DECISION DELEGATED TO HEAD OF PLANNING

Application No: H16-0559-24 **Applicant:** Mr Scotney

Proposal: Proposed two-storey side extension, single-storey rear extension, replacement of existing dormer roofs and internal alterations

Location: 127 Edinburgh Drive Spalding

Side Elevation (N)
Scale: 1:100

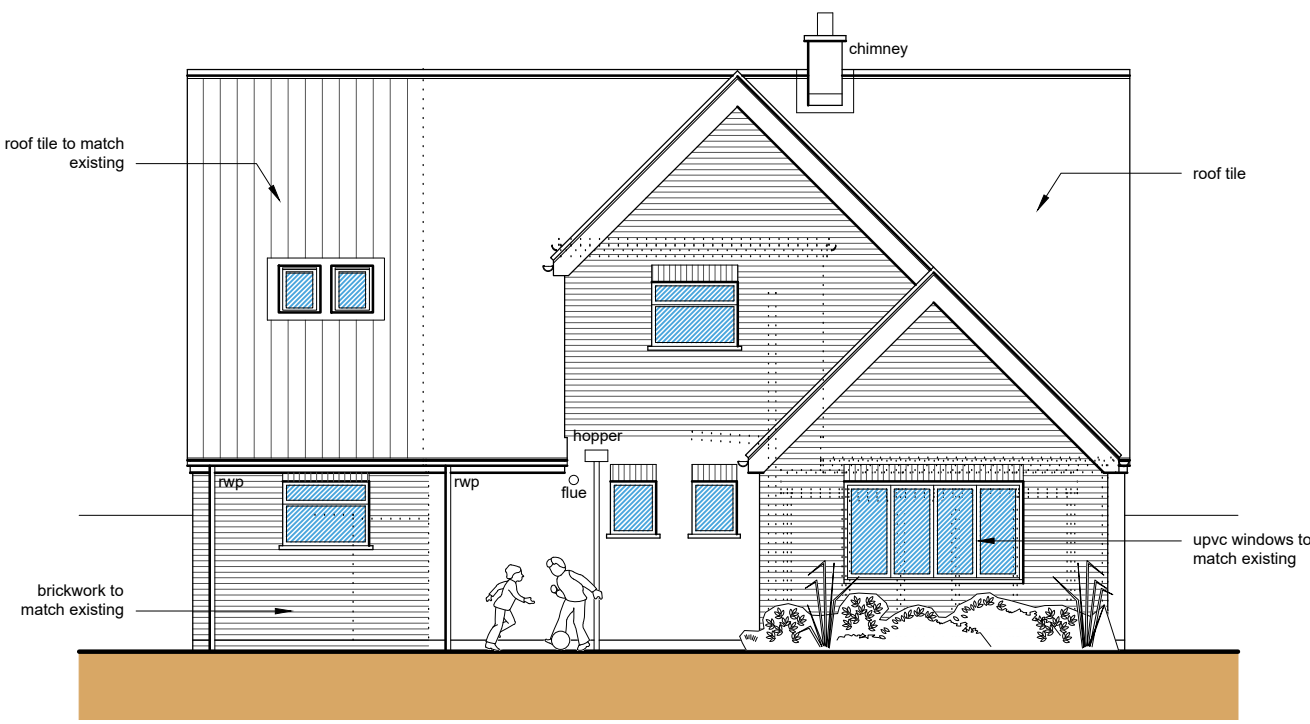
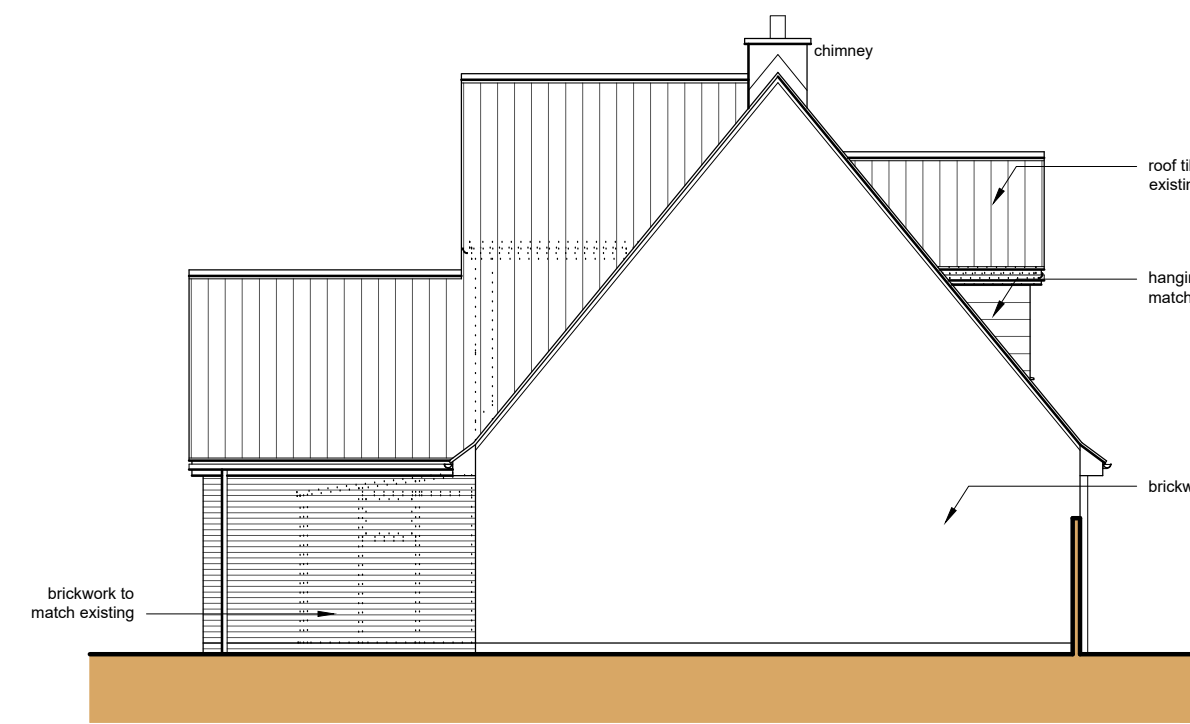
"concerned that if the house to the right of the plot has side windows these will be blocked by the proposed extension. This is not shown or mentioned"

The proposed side extension would be located 1.236 metres from the boundary line with 40 Windsor Drive, with the southern elevation of 40 Windsor Drive sitting approximately 1.2 metres beyond that. Two windows are present in the relevant elevation of 40 Windsor Drive, although it appears that only one leads onto a habitable room. Concerns were raised, in particular by the comments of the local Councillor, regarding this arrangement and the potential loss of light this would create; although no objections have been received from the neighbouring residents. In order to ensure no such impact would occur, a shadow analysis was requested.

The submitted information shows that the extension would only have an extremely minor impact in terms of overshadowing and only during the winter months. From this submitted information, it is considered that the proposal would not have an unacceptable impact with regard to overshadowing, as to warrant refusal.

First Floor Plan
Scale: 1:100

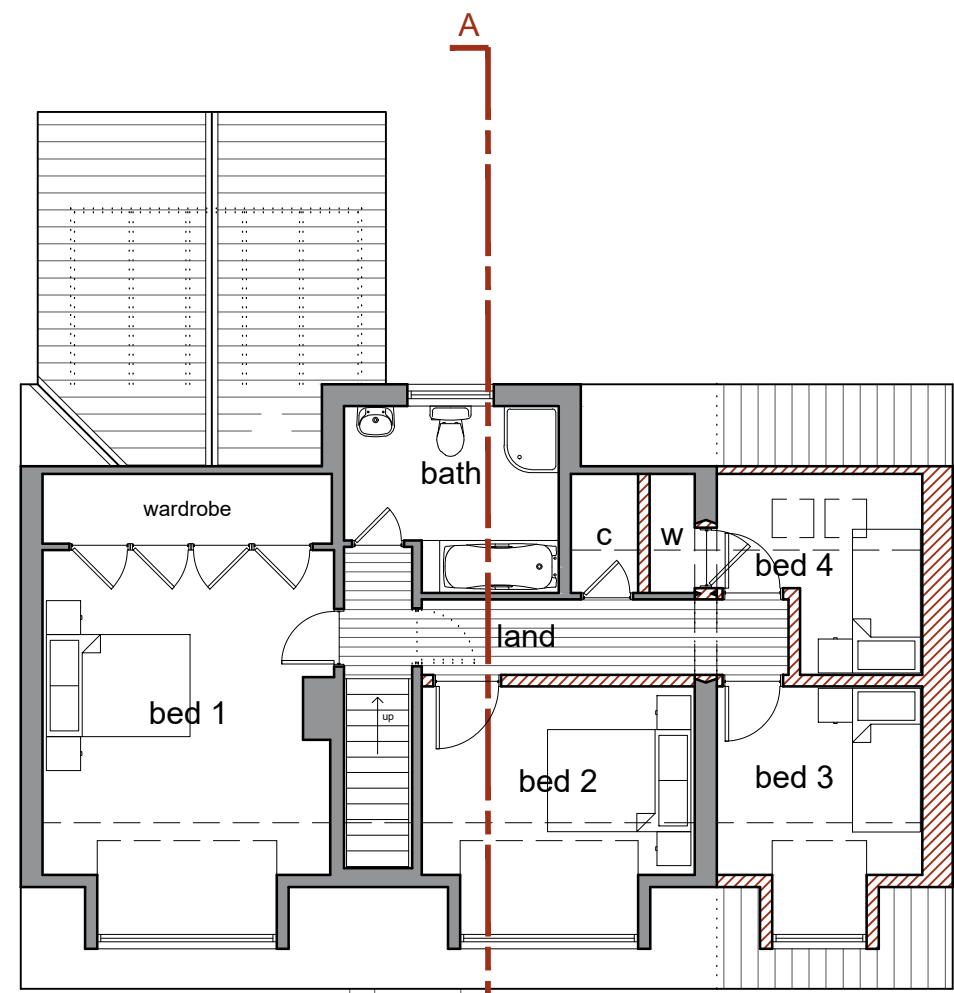
The proposed west facing windows, connected to bedroom 4, would be located approximately 1.8 metres above first floor level (measured from the bottom of the window). At this height, the vast majority of users would not be able to gain views from this window, and as such, the actual level of overlooking generated by this change is lowered.

Site Plan
Scale: 1:200

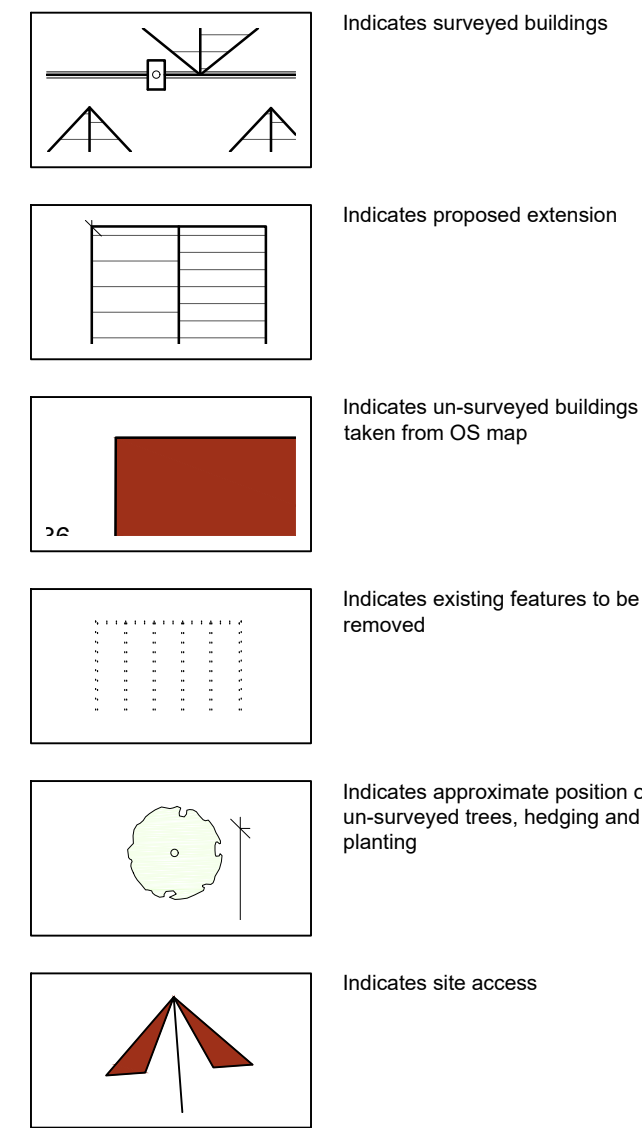
As the total number of bedrooms would rise from two to four, an additional parking space is required. Despite the proposal removing some of the driveway, it is considered that adequate room has been maintained on site to accommodate this parking level.
